V1_Grading & Erosion Control (GEC) Plan_COMMENTS.pdf Markup Summary

Glenn Reese - EPC Stormwater (5)

MONUMENT ACADEMY

PHASE 2
CONSTRUCTION DOCUMENTS

C3.4-A

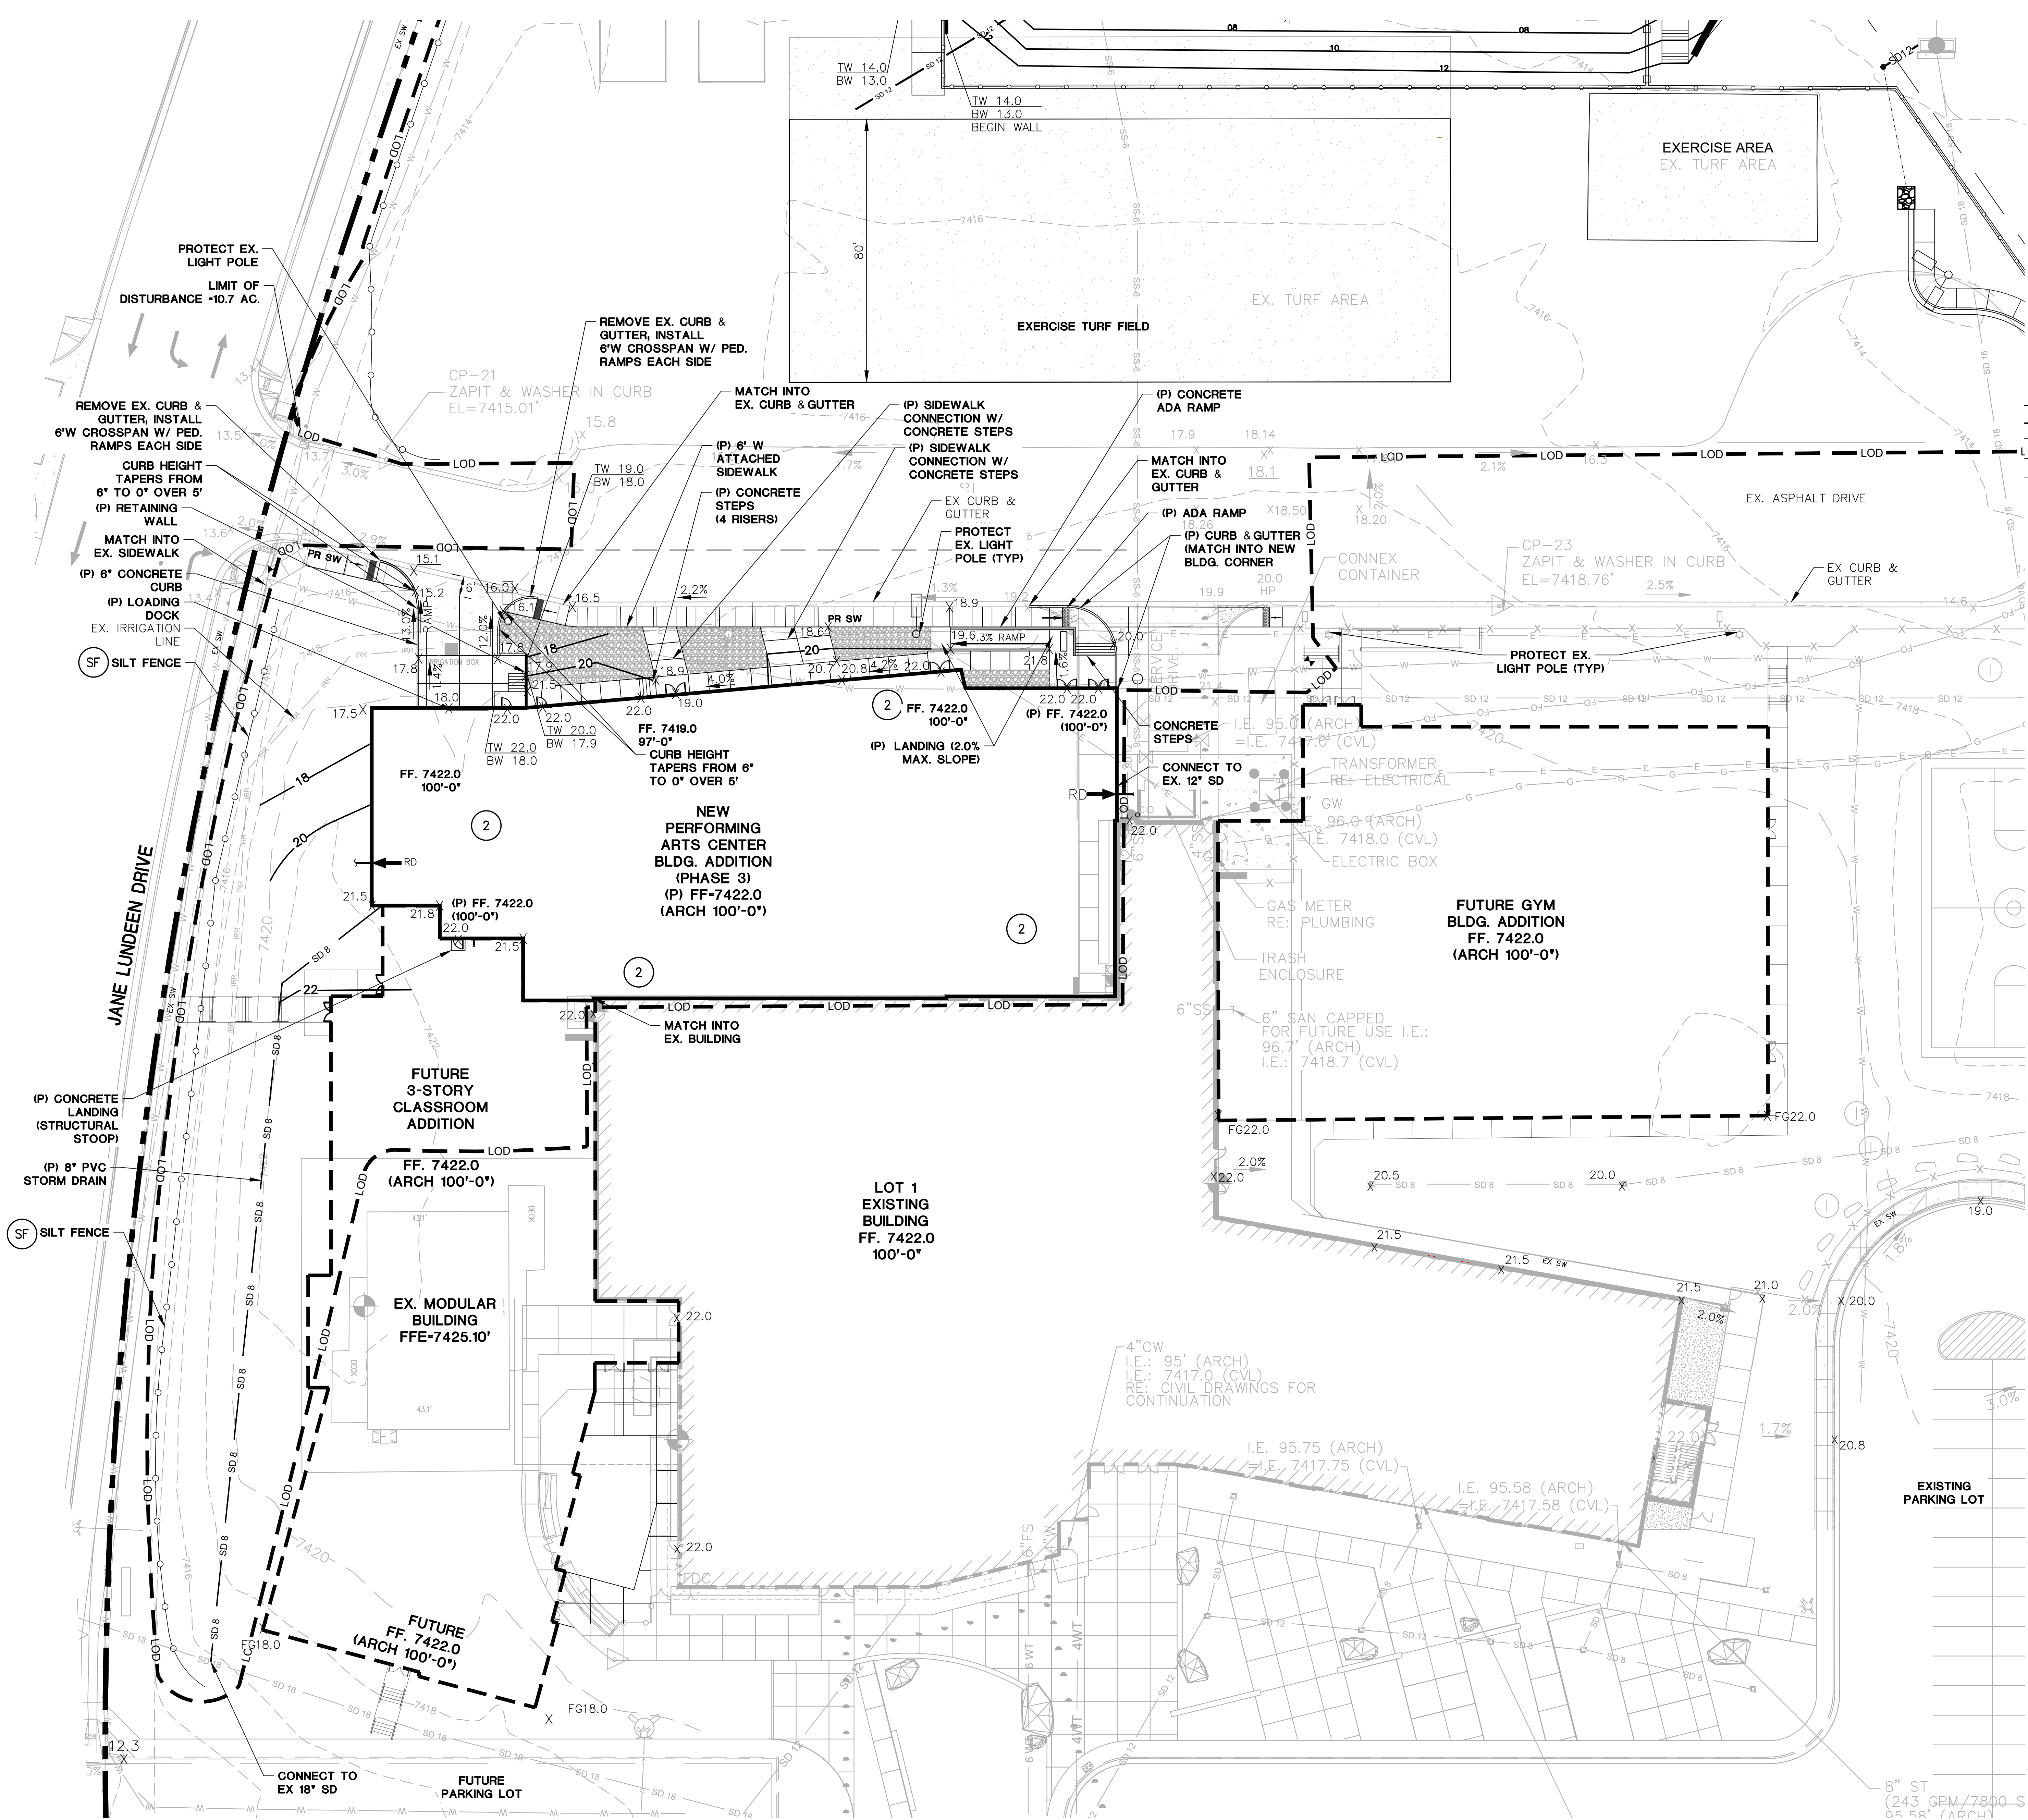
So do you want this tied to the current ESQCP? Or will you come in for another ESQCP (if need be) at a later date for this Phase 3? Because currently the ESQCP Form only lists Phase 2. It's just confusing because this Phase 3 and other future buildings/improvements are included in this Phase 2 planset. Please try and clarify the phasing in this planset. I think simply writing "future" next to "Phase 3" would clarify the intent somewhat (if that is in fact your intent). But then the LOD is showing extending over to this building, so our inspectors are going to think this is part of the Phase 2 ESQCP... like I said, please try to clarify this. Ideally future work and grading would not be shown on this planset (or at least the GEC Plan sheets) at all because it is not related to the ESQCP.
